Application: SSI 7485

I write regarding the proposed modification to M4-M5 Link, Mod 2 The Crescent overpass and changes to pedestrian infrastructure in North Annandale, Rozelle and Rozelle Bay Foreshore area.

**Figure 4 | Proposed modification** (Source: Design Amendment Report)

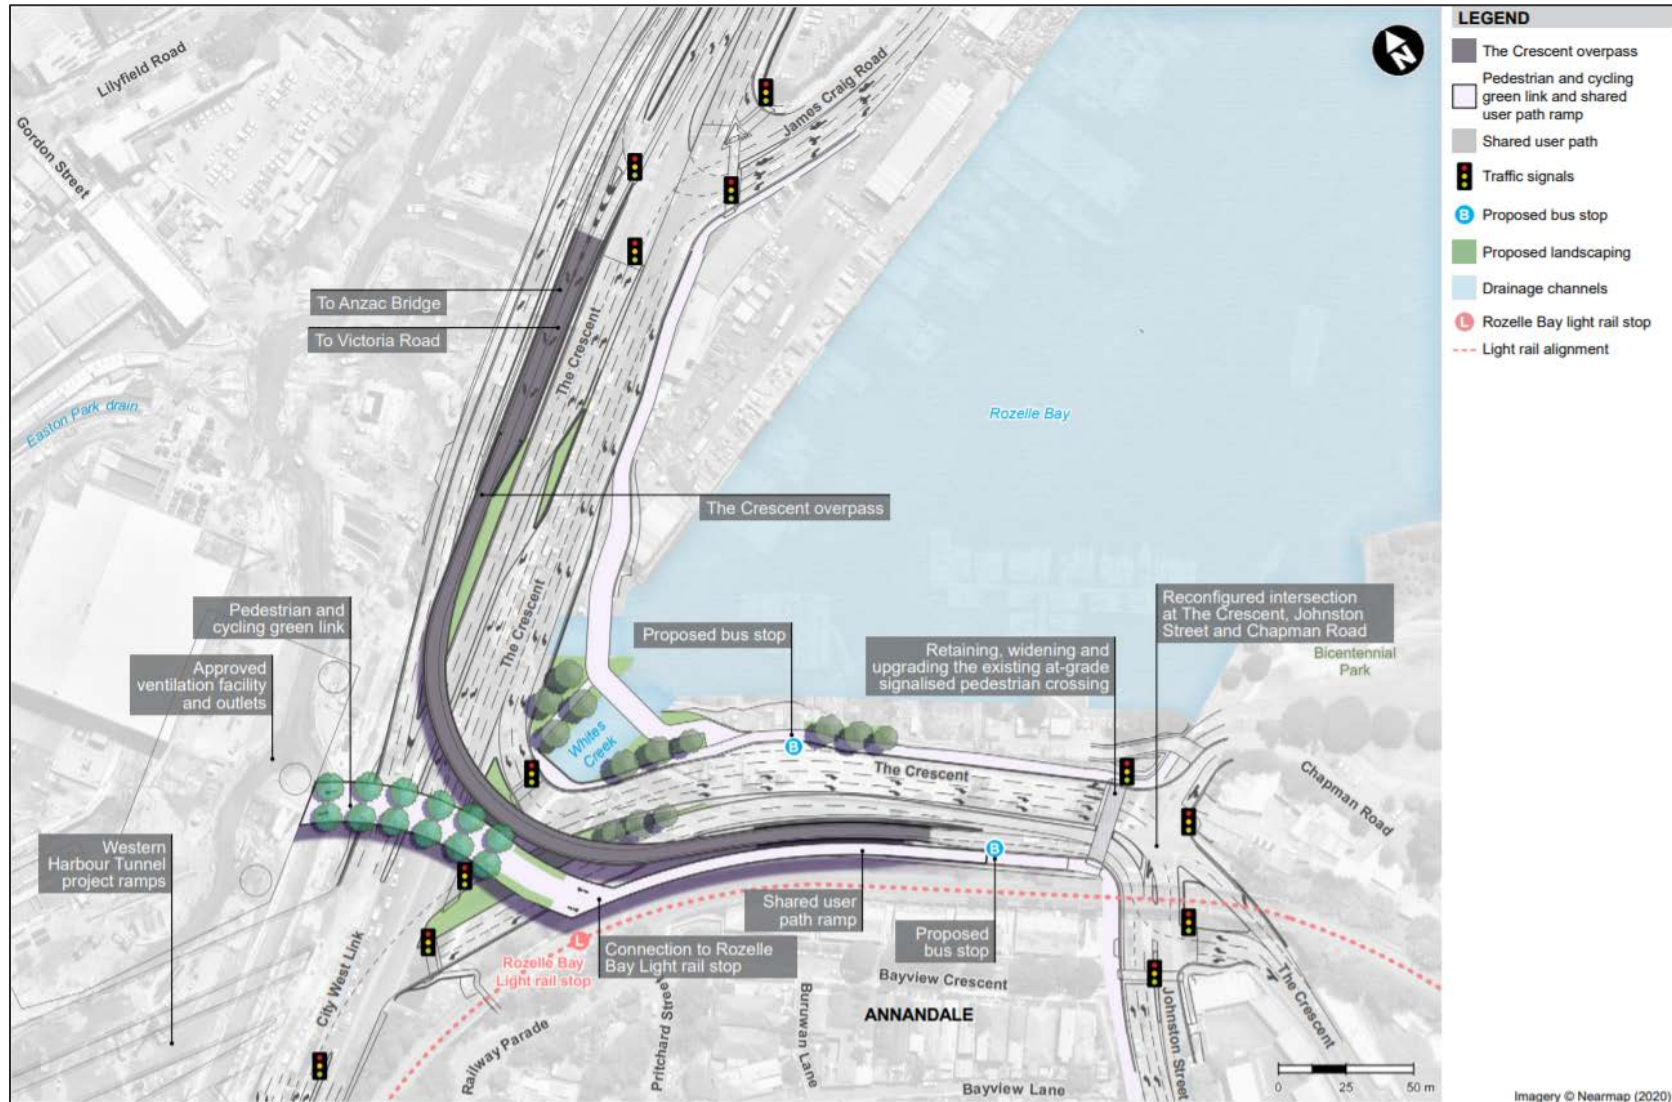
I request RMS work with the community to explore alternate design options to the proposed new car overpass design and the changed pedestrian and cyclist links. I am seeking the reinstatement of the safe, direct access from the approved EIS GreenLink to create a continuous green open space connection from the Rozelle Rail yards and Annandale to the foreshore. The GreenLink was more than just a walk way - it put people central to the design, maximising safety, and providing much needed accessible open space for the community now and into the future Bays Precinct design.

- The significantly reduced safety and increased risk for pedestrians and cyclists with removed access over The Crescent to Bicentennial Park and the increased traffic along Johnson Street.
- Being required to cross five sets of pedestrian lights at The Crescent as my option to reach the foreshore from Annandale or from Rozelle Bay light rail stop.
- Removal of direct active links to the foreshore, cutting the community off from the area and the proposed revitalisation of the entire Bays Precinct, including linking the Light Rail and Bus stops to a Ferry wharf and Metro station.
- Urban and landscape design that is being built before a finalised Masterplan for the area.
- Traffic changes that limit movements around the suburb and create further congestion in the local streets of Annandale, Forest Lodge, Glebe, Lilyfield and Rozelle with no planning to deal with these.

- Reinstatement of the GreenLink connecting communities and green open space from Rozelle to Bicentennial Park
- Relocate and design pedestrian and cyclist connections that are continuous, safe and direct.
- Design the modification infrastructure and active links in response to the character of the suburbs, the location of the foreshore and its potential future development.
- Provide pedestrian and cyclist paths that maximise people safety and do not force them onto busier streets, unsafe concrete plazas and caged walkways.
- Integrate active and direct connections to all active transport – including the future Metro West and Foreshore Ferry Wharf
